CHARLOTTE-MECKLENBURG PLANNING COMMISSION
INTER-OFFICE COMMUNICATION

DATE: August 7, 1989

SUBJECT: Administrative approval for Petition #89-12(c) Cooper Companies Tax Parcel #099-331-02

SITE PLAN
SCALE: 1" = 40'-0" 2/14/89

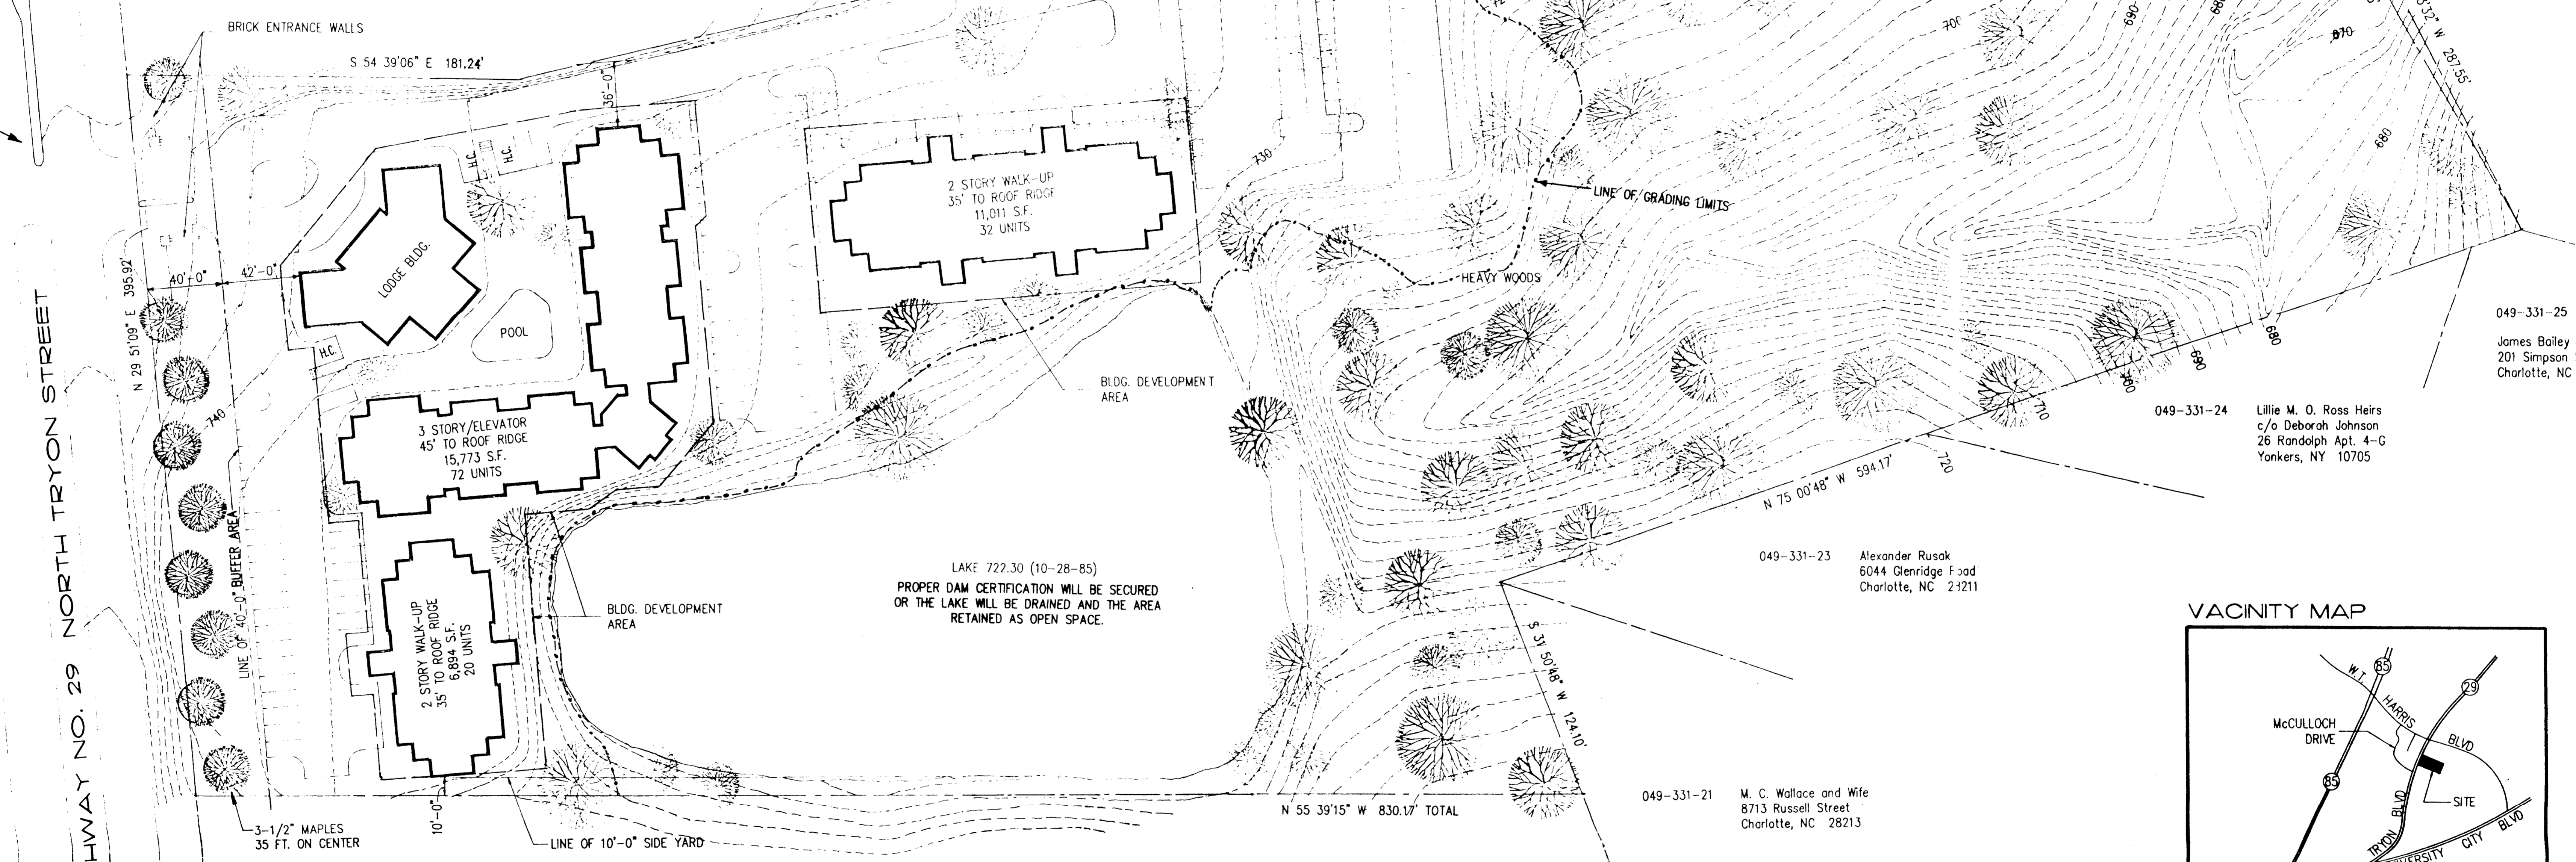
Attached is a revised site plan for the above referenced zoning petition. The plan has been revised to relocate a parking lot from the rear of the site to between two proposed buildings. The footprint of the Lodge Building has also changed slightly. Since these changes are minor and do not effect exterior property lines I am administratively approving this plan. Please use this plan when evaluating requests for Building Permits.
